**Subject: EES comments on Environmental Impact Statement for Moriah College
Redevelopment – Queens Park campus – SSD-10352**

Subject: EES comments on the Environmental Impact Statement for Moriah College redevelopment – Queens Park campus – SSD-10352

The Environment, Energy and Science Group (EES) has reviewed the following documents:

A summary of possible plant species for further development at detailed design of each stage is provided as a guide and point of commencement for the final planting selection and arrangement.

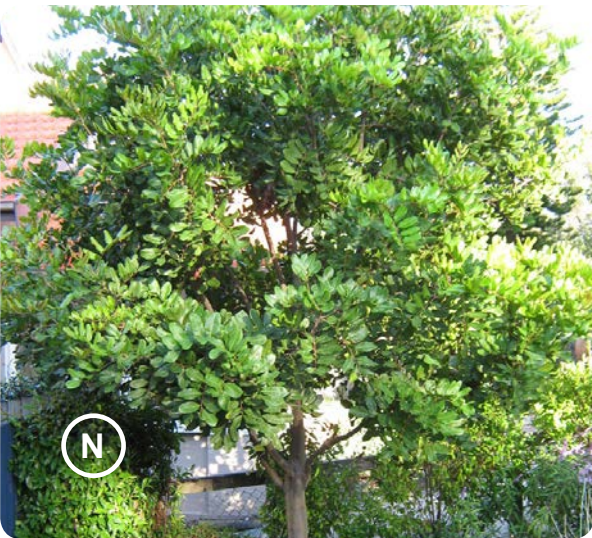
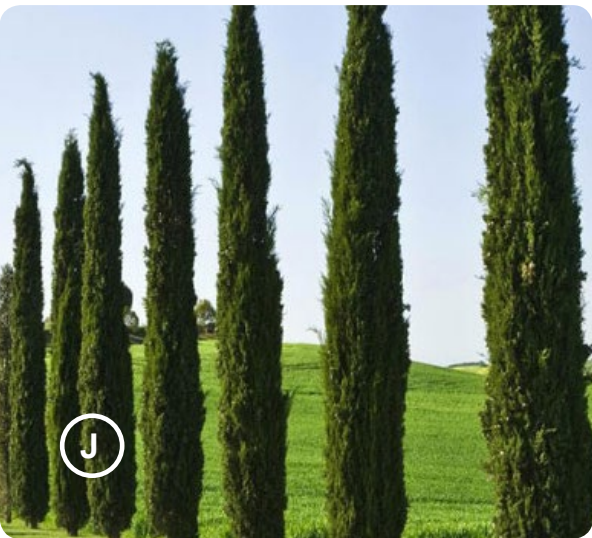
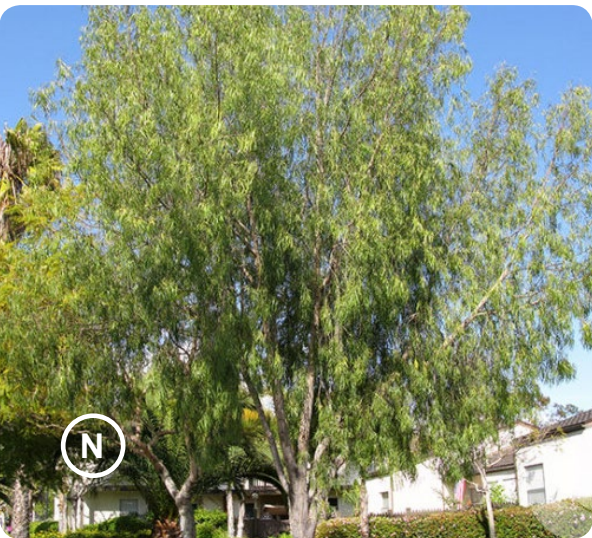
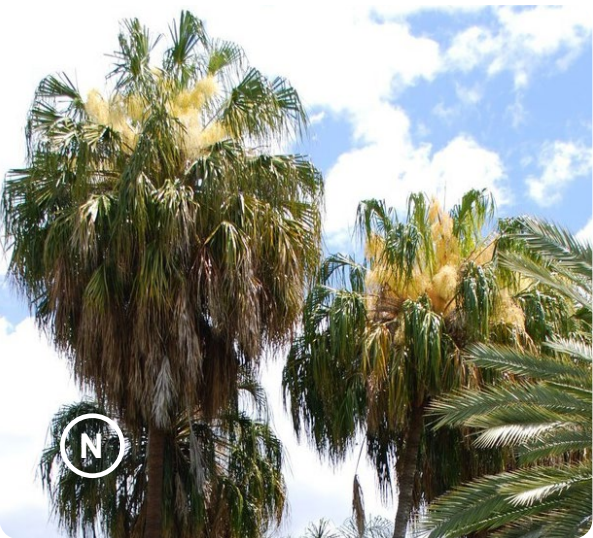
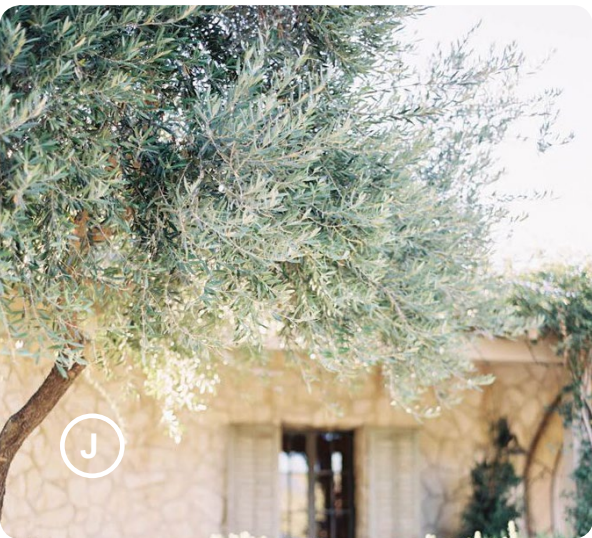
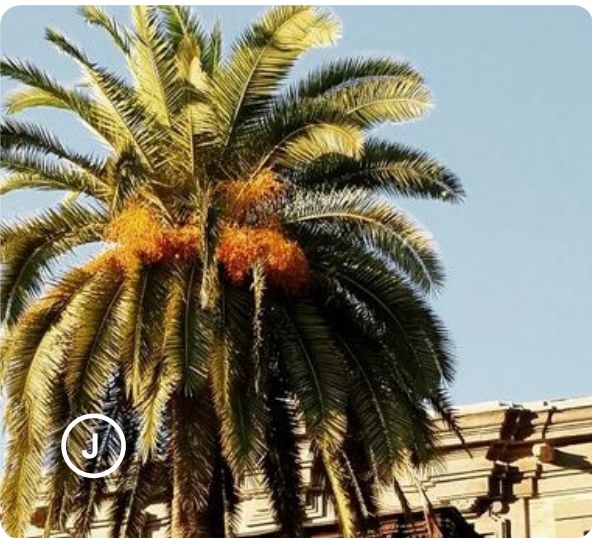
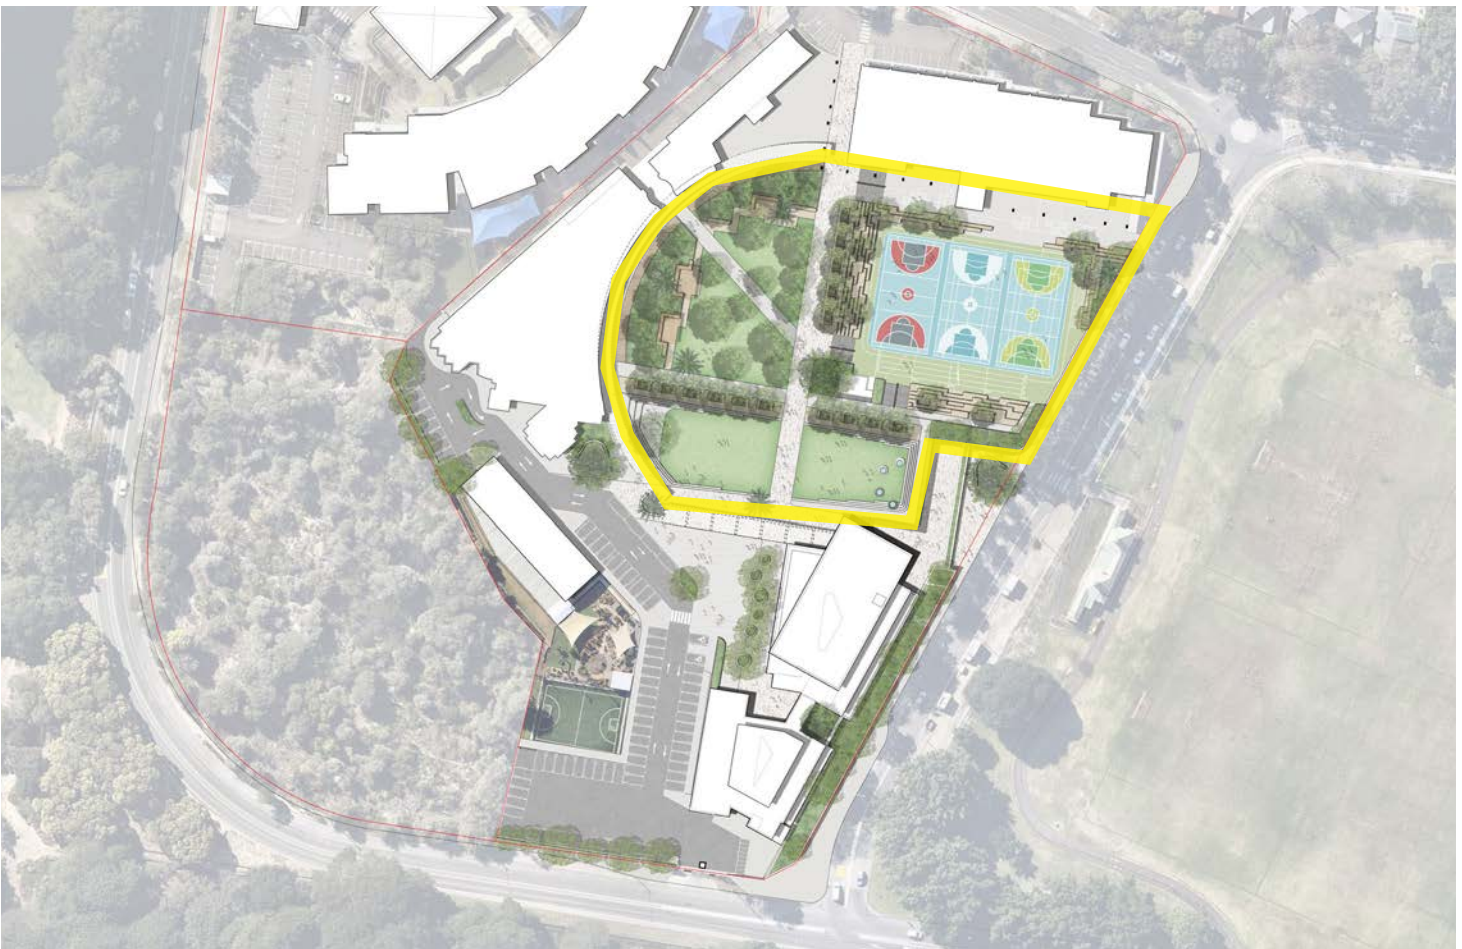
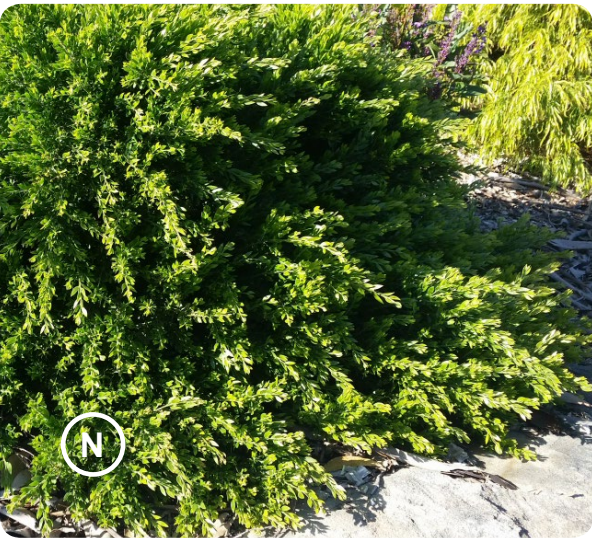
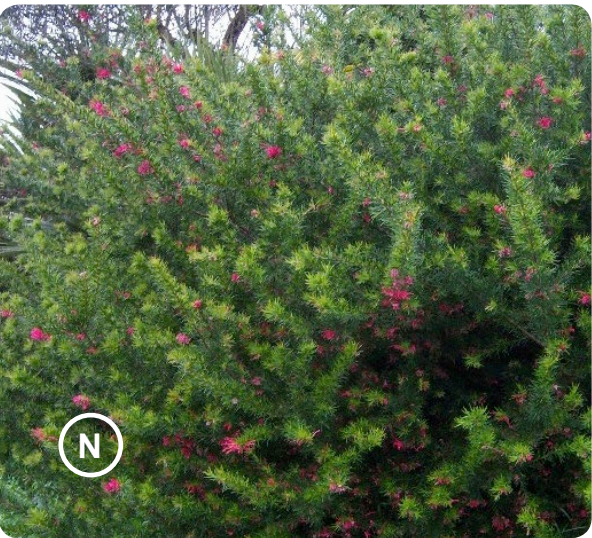
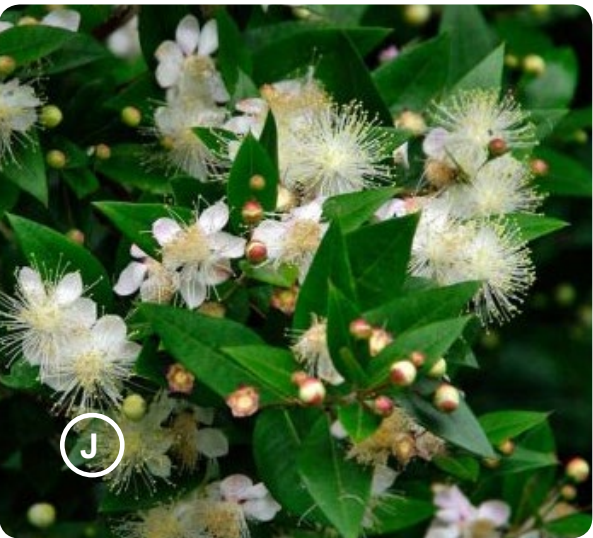
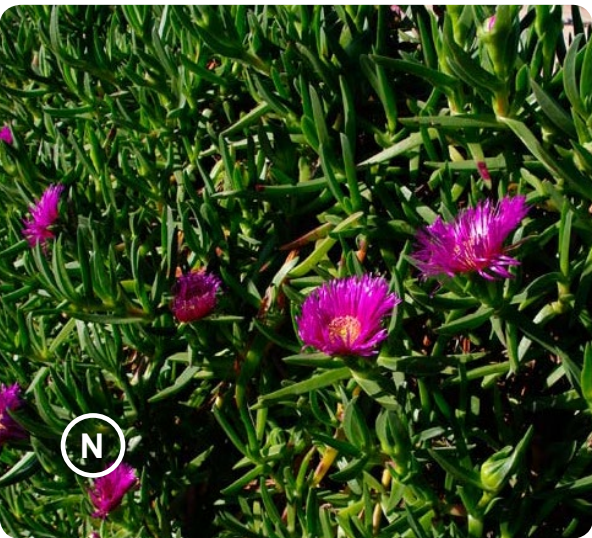
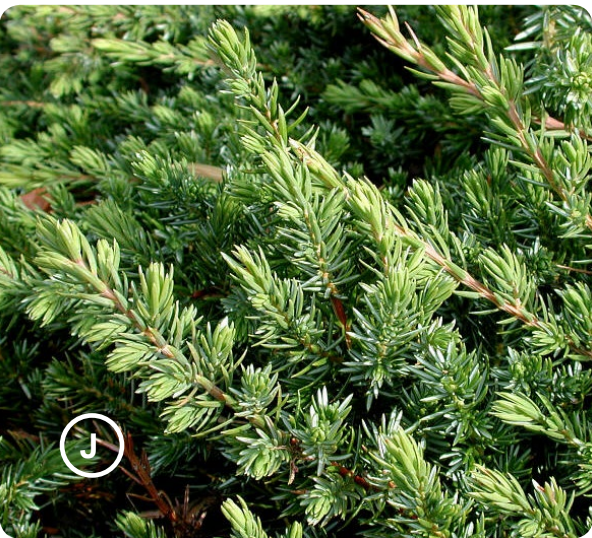
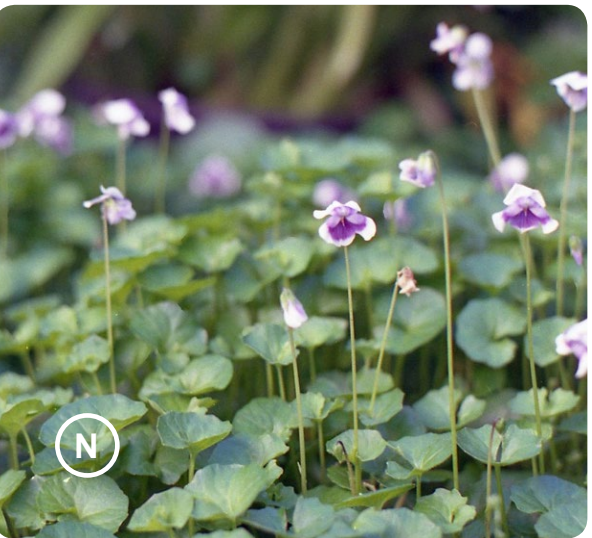
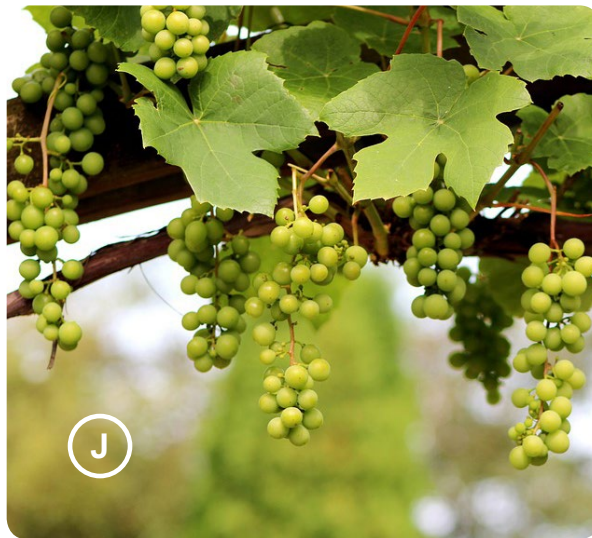
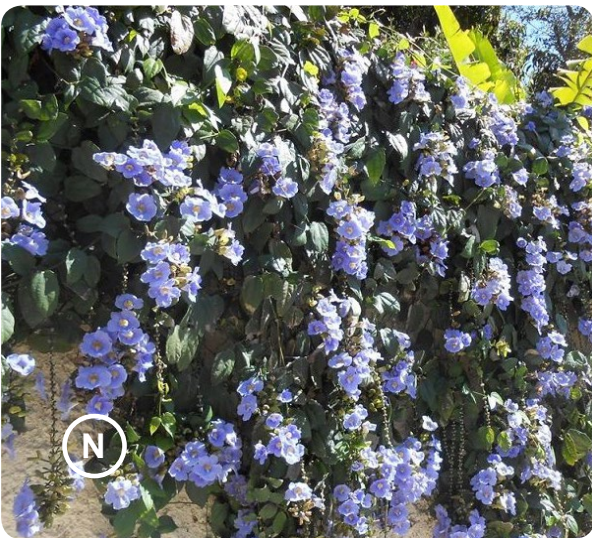
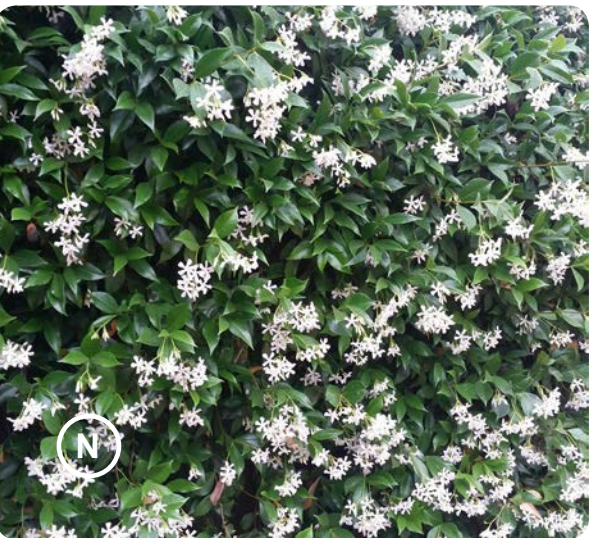
The EIS proposes to plant native species of trees, shrubs and groundcovers (Table 17, page 72) while the Sustainability Report states the project is implementing extensive native vegetation endemic to the local area (section 4.7, page 18). The Landscape Report however indicates that a mix of new deciduous and evergreen trees are to be planted in the Reflection Garden and it indicates the planted species have been selected for various applications including edible, medicinal, functional, cultural and environmental benefits (page 18).

The planting of exotic and non-locally occurring native plants at the site in the past has impacted ESBS at the site. The CPMPT York Road Vegetation Management Plan (VMP) 2002, for example notes that ornamental trees planted along York Road in the 1950s have naturalised and are now found throughout the York Road bushland site (page 34). The large ornamental canopy trees have caused major changes in light availability, soil moisture and nutrient availability and they are thought to be a significant factor in the suppression of indigenous understorey species (pages 34 and 36).

- the areas required under previous development approvals be retained, rehabilitated/restored and maintained in perpetuity as ESBS in accordance with those approvals
- the Landscape Report and mitigation measures are amended, and a condition of consent is included which requires the landscaping for this SSD, particularly for the buffer areas adjacent to Lot 23 and Lot 1, to use a diversity of local native provenance species from the relevant ESBS native vegetation community that occurs and once occurred on the site to improve biodiversity (rather than use exotic species and non-locally occurring native species).
- The Response to Submissions (RTS) demonstrates that the plant species to be used in the landscaping are species of local provenance from the ESBS native vegetation community.

1. Enough area/space is provided on site to allow the trees to grow to maturity.
2. Tree planting at the site shall use advanced and established local native provenance trees with a minimum plant container pot size of 75-100 litres, or greater for local native tree species which are commercially available. Other local native tree species which are not commercially available may be sourced as juvenile sized trees or pre-grown from provenance seed.
3. The landscaping - particularly for the buffer areas adjacent to Lot 23 and Lot 1 shall use a diversity of local native provenance trees, shrubs and groundcover species (rather than exotic species or non-local native species) from the relevant ESBS native vegetation community which occurs and once occurred on site.

4. The Landscape Plan shall include details on:
- a) the native vegetation community that occur or once occurred on site
 - b) a list of local provenance tree, shrub and groundcovers to be used in the landscaping
 - c) the quantity and location of plantings
 - d) the pot size of the local native trees to be planted
 - e) the area/space required to allow the planted trees to grow to maturity
 - f) plant maintenance including on-going weed management. The planted vegetation should be regularly maintained, monitored and watered for 12 months following planting. Should any plant loss occur during the maintenance period the plants should be replaced by the same plant species.
